From: Sarah Burrow <Sarah.Burrow@arun.gov.uk>
Sent: 23 October 2019 11:47
To: Amber Willard <Amber.Willard@arun.gov.uk>
Subject: RE: Planning Consultation on: AL/83/19/DOC

Engineers Comments Regarding Surface Water Drainage

APPLICATION NO: AL/83/19/DOC
Registered: 2nd October 2019
Site Address: Little Glebe Littleheath Road Aldingbourne BN18 0SR
Grid Reference: 494545 107392
Description of Works: Approval of details reserved by condition imposed under Ref AL/111/18/HH relating to Condition No 3 - surface water drainage.

Project:	Little Glebe	Date:	Mar 2019	Made by:	KS	Sheet No.	1
CALCULATION SHEET		Job No.	1904	Chkd:	-	Rev.	A

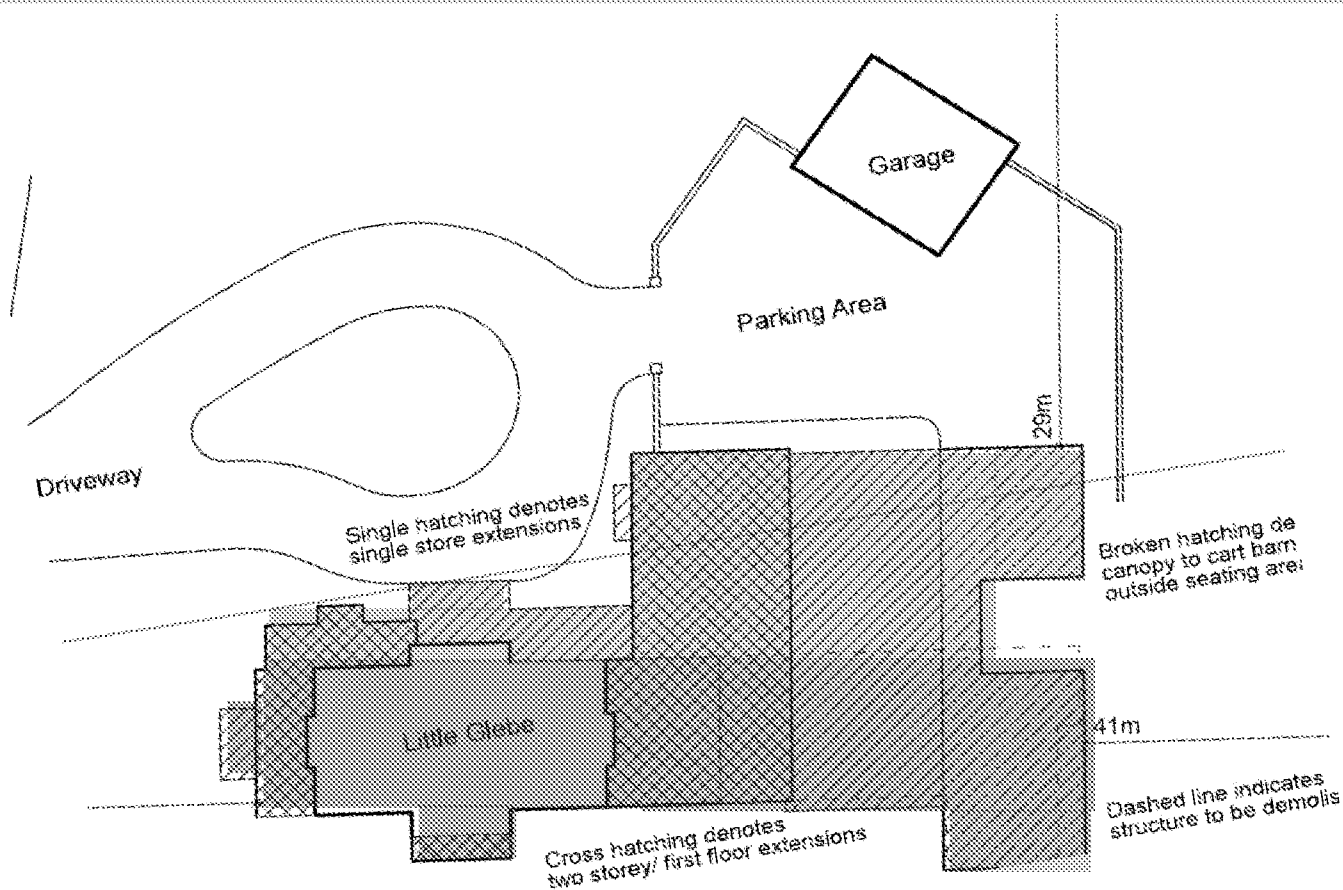
In addition the invert and cover levels have still not been applied to the drawing and we have no drawings for the proposed silt traps.

1. The drainage layout provides two proposed sites for soakaways, yet only one infiltration test has been completed and this not in accordance with BRE 365. The infiltration test was completed to a depth greater than that of the soakaway(s) proposed. The test was completed once rather than filled three times. No location for this test has been provided.
2. No formal winter ground monitoring was completed.
3. The drainage layout has no invert or cover levels.
4. The base of the bottom of the soakaway crates described on the drainage layout indicate that the depth will be greater than that described on the proposal checklist.

1. Winter groundwater monitoring and infiltration testing are completed in accordance with BRE 365 at the proposed soakaway locations and depths. The results of which are used to inform the amended design, submitted with appropriate calculations, invert and cover levels. Or,
2. A higher factor of safety (3) is used to compensate for inadequate testing, thus upsizing the soakaway(s). The updated calculations are submitted alongside invert and cover levels on the new drainage layout.
